**KIRKLEES METROPOLITAN COUNCIL  
INVESTMENT & REGENERATION SERVICE**

Reference No:	<b>2023/62/91421/E</b>
Site Address:	17, Market Street, Heckmondwike, WF16 0JY
Description:	Change of use and alterations from two flats and one retail unit to form six bedsits and the retention of one retail unit
Recommending Officer:	Nina Sayers

**DECISION - REFUSED**

## **Officer Report**

GROUND FLOOR PLAN

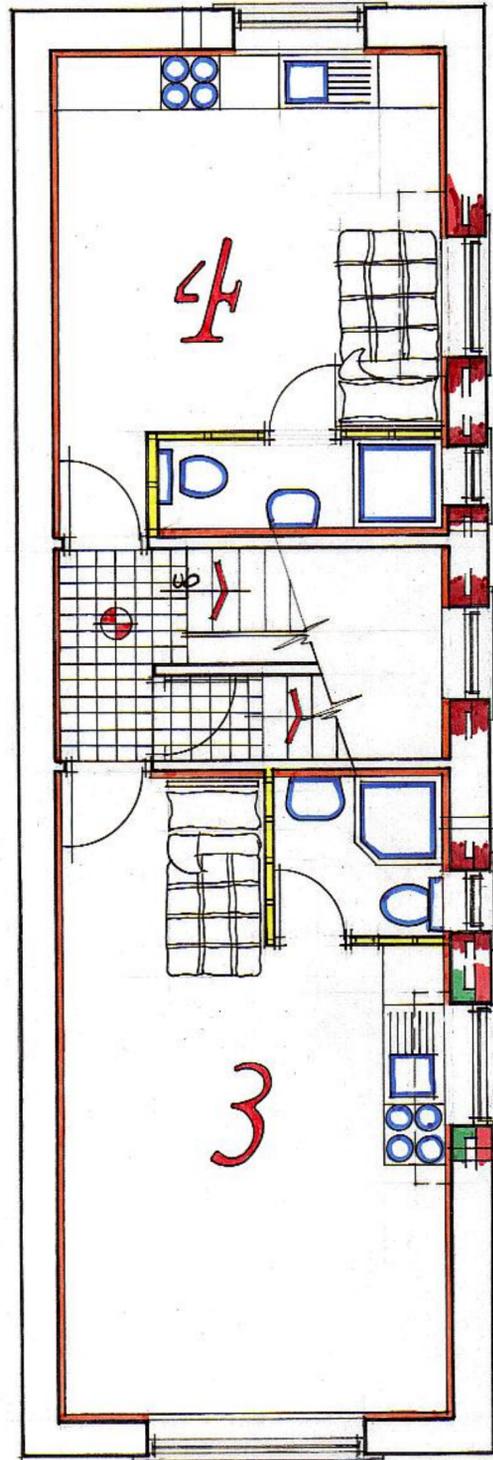
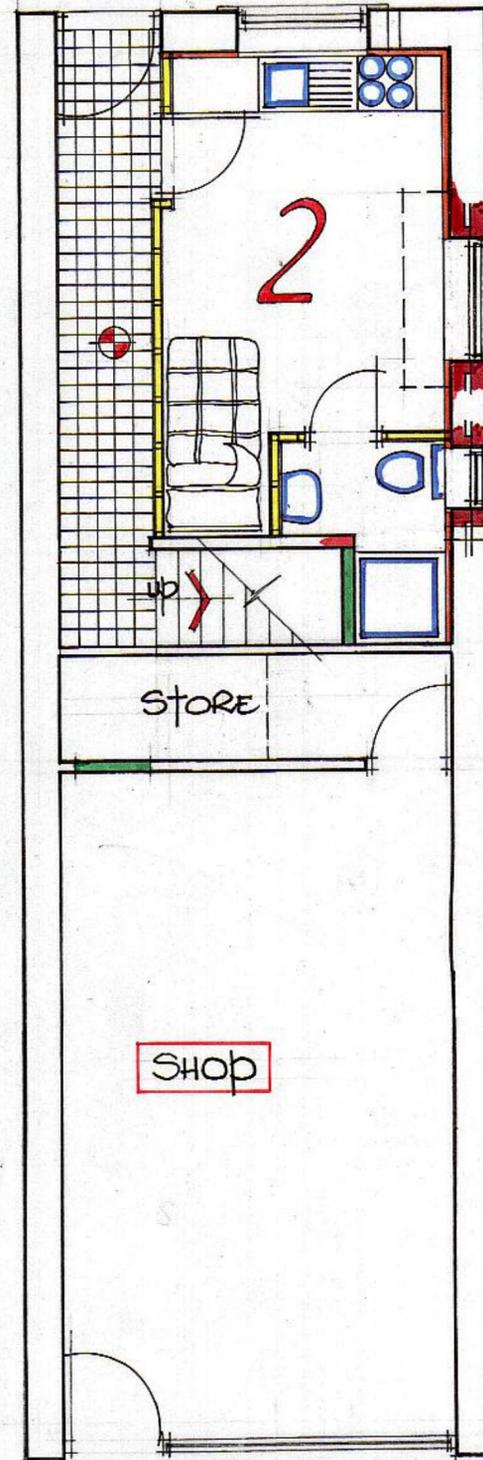
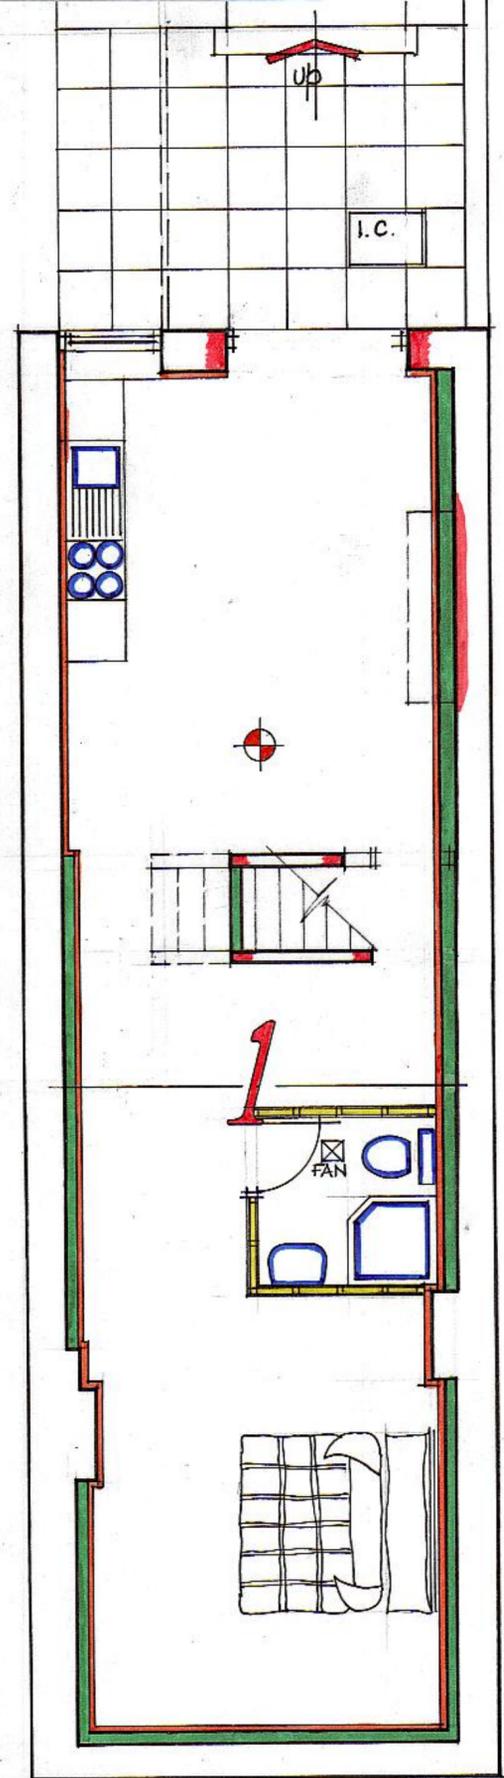
The proposed openings in the side elevation would face directly onto an open green space which serves seating for members of public. This would include an opening at ground floor level which would serve a primary inhabited space. Therefore, it is considered that the proposal would result in significant overlooking harm to the future occupiers of bedsit no.2 as labelled on the proposed floor plans.

The bedsit located within the basement (labelled as bedsit no.1 on the proposed floor plans), would have two windows within the most easterly elevation, whilst this would provide some light to the kitchen area it would be set down from ground level and behind a stairway, therefore sufficient natural light would not be provided to these windows and the outlook would be minimal. There would be no openings serving the bedroom area, which is set to the front of the property, so there would be no natural light or outlook to this primary inhabited space. This would be detrimental to the amenity of any future occupiers.

The proposed bedsits all fail to meet the minimum recommendations for internal floor areas as set out within the Nationally Described Space Standards for the number of bedrooms they serve. The NDSS sets the minimum recommendation, and it is considered, in this instance, that the proposed floor space and layout would not provide adequate living space for future occupants which would be at the detriment of future occupiers, which is contrary to LP24 of the Kirklees Local Plan or paragraph 130 of the NPPF. There would also be very limited amenity space within the curtilage of the property. Due to the constraints of the site, there is a no provision for more amenity space to be provided within the site.

SIDE ELEVATION

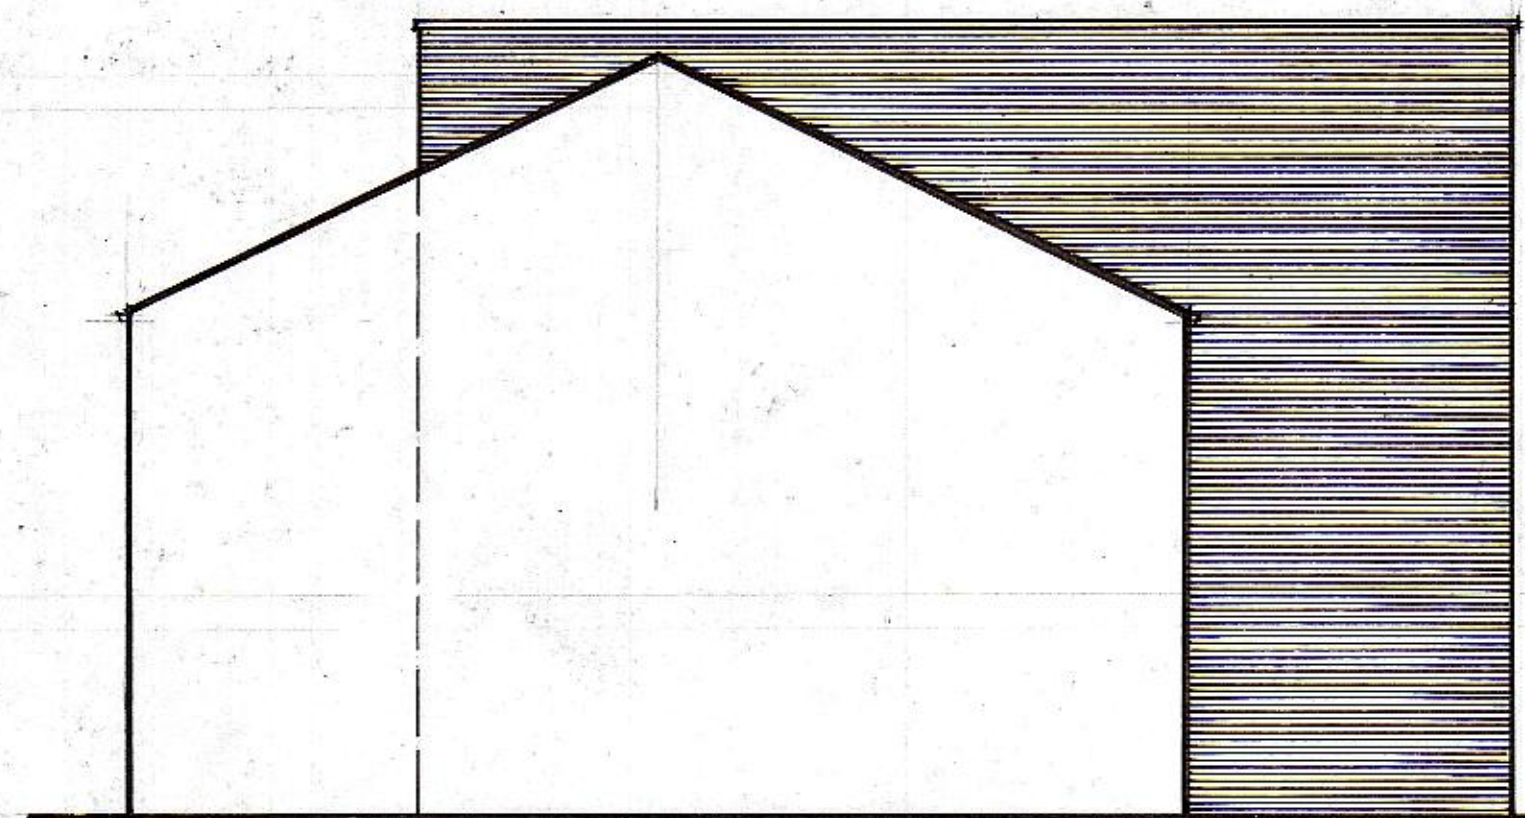
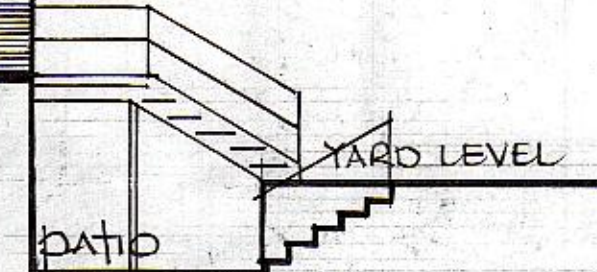
The proposed development would involve minor works to the exterior of the property. The front elevation would remain unaltered, and the rear elevation would include an additional door and window at basement level. This would align with the existing openings in the rear elevation and given that it would be below ground level and to the rear, it would not be in a prominent location.

There would be significant additional openings proposed to the existing blank side elevation to allow for windows to the proposed bedsits. Due to the design and siting of the existing property, the side elevation is in a prominent position within the street scene and town scape. It is adjacent to a small open space which provides a seating area within Heckmondwike Town Centre, adding to the prominence of the elevation. The proposed windows would appear clustered and would harm the visual amenity of the host building and wider street scene at the detriment of the town scape.

2. The proposed development due to the poorly articulated fenestration details would appear incongruous in a prominent location which would harm the visual appearance of the host building, wider street scene and the town scape of Heckmondwike Town Centre, which would be at the detriment of visual amenity. Thus, the scheme fails to comply with LP24 of the of the Kirklees Local Plan, chapter 12 of the NPPF and the Housebuilders Design Guide SPD.
